**Consultation Response from KC,
Lead Local Flood Authority**

2022/93516 adj, 71, Southern Road, Cowlersley, Huddersfield, HD4 5TJ

Erection of one dwelling with detached garage

Date Responded: 5th June 2023

Proposed Site Section 1
 1 : 100

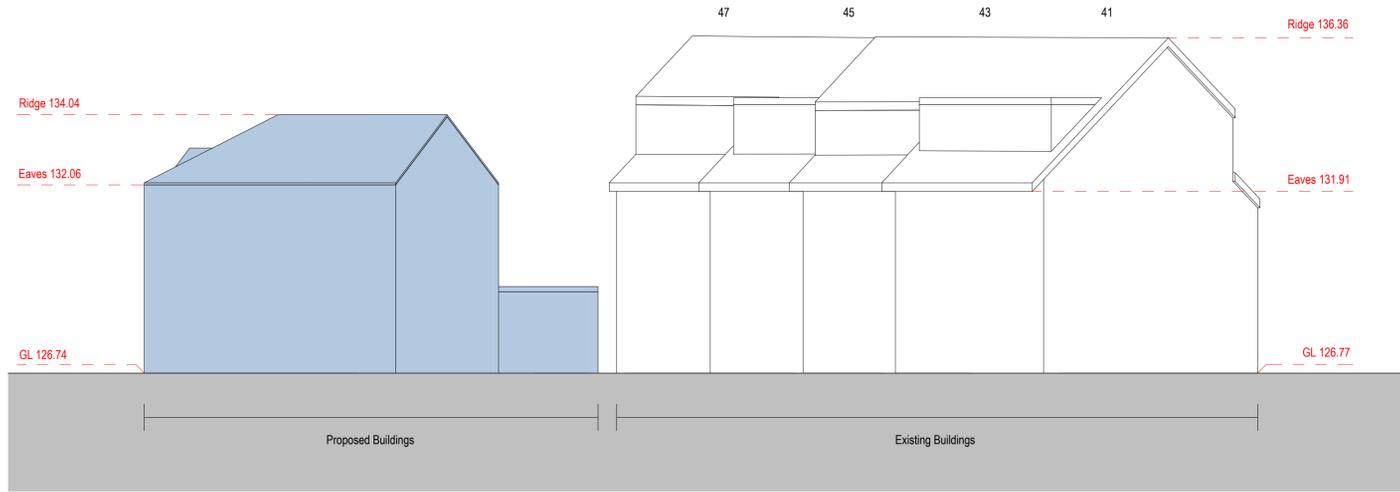
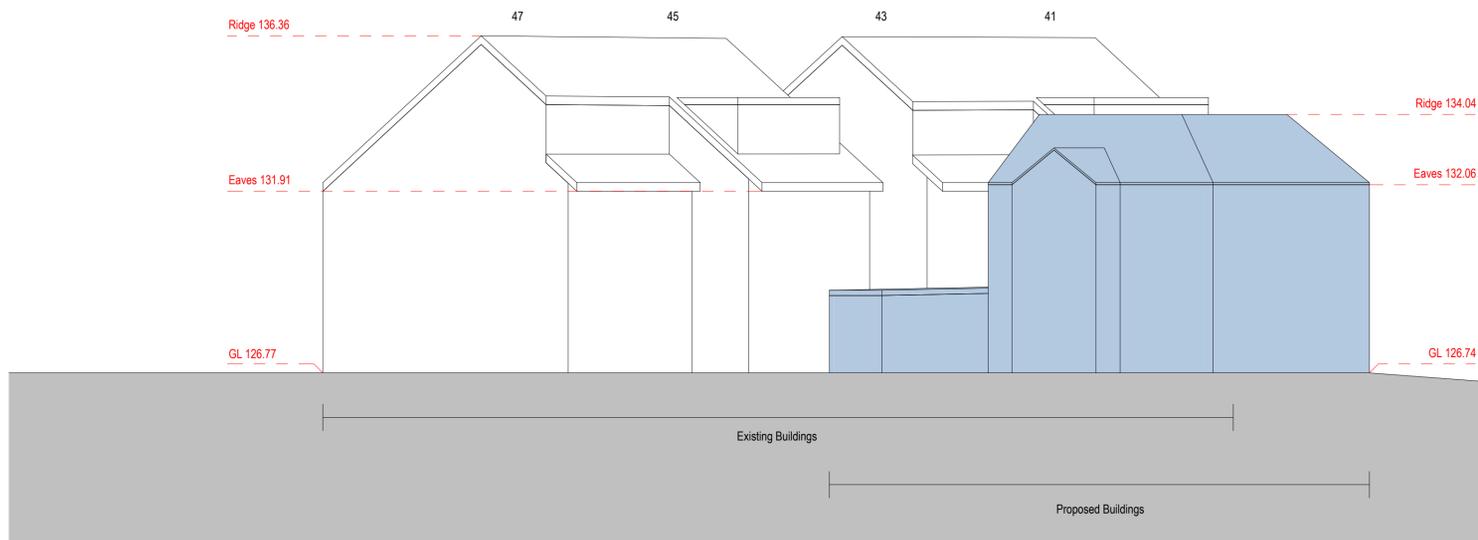
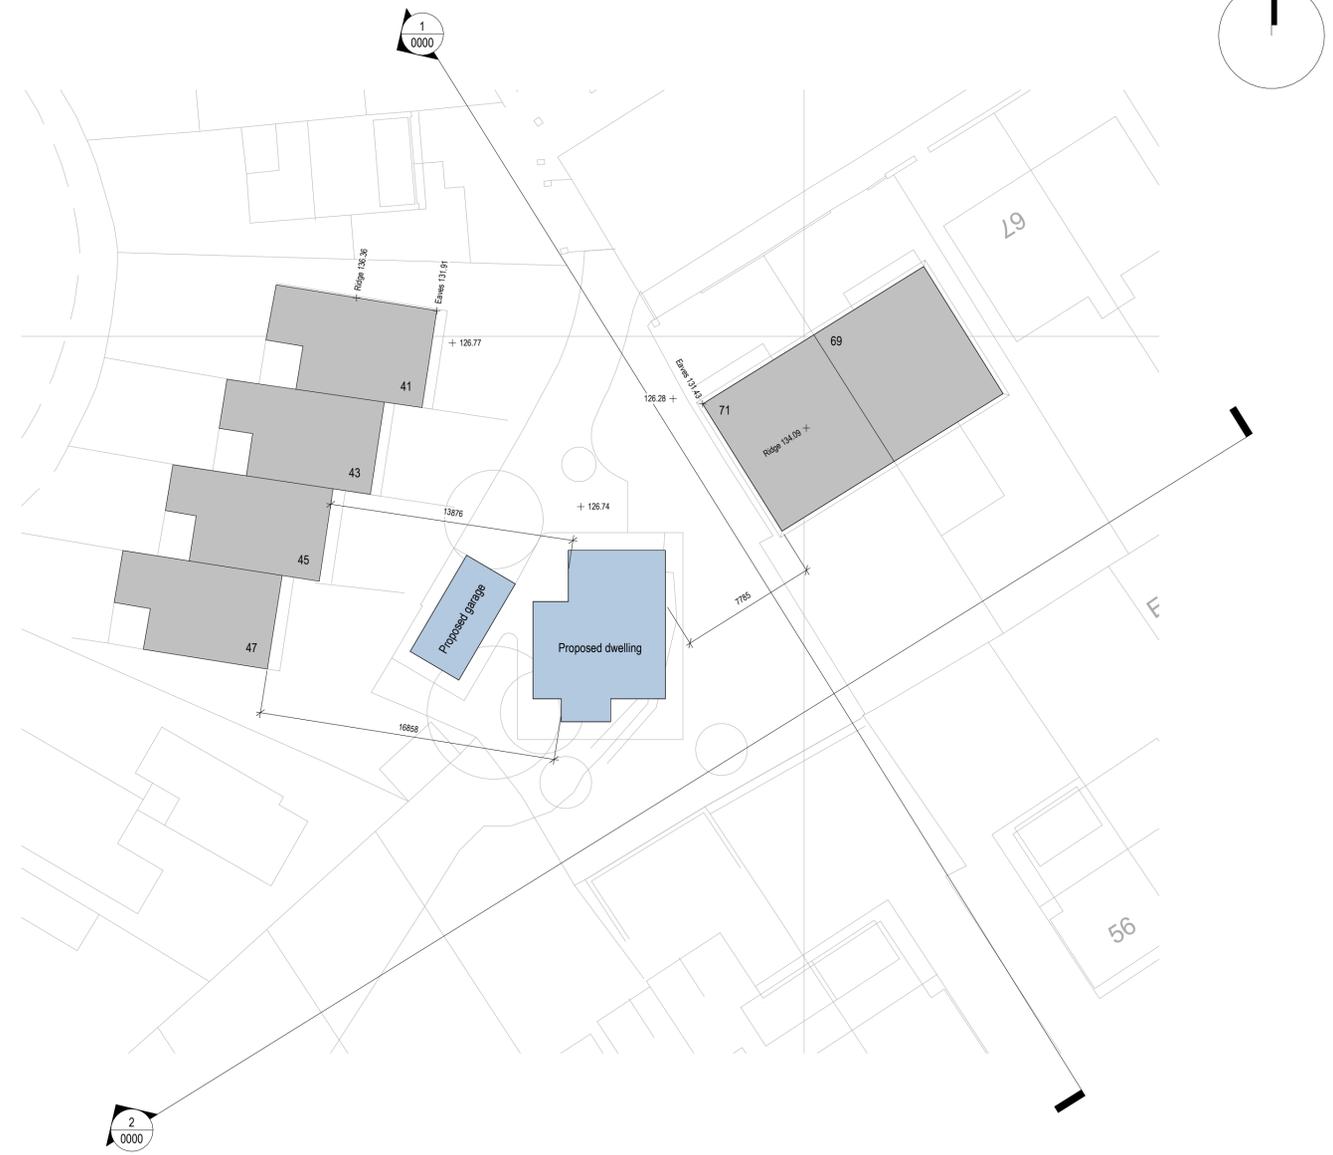
Calculations have been sent that we think are to demonstrate self-cleansing flows. A trench diversion has been included in the layout, for the watercourse. The sides may well pose a hazard for you children and should be CDM assessed for the design. Shallow gradients of a swale would be an improvement.

There is some confusion about future ground levels and how existing properties are to be protected. Curbs and dwarf walls could be considered to push overland flows through site. We would not expect the side of the building to be used.
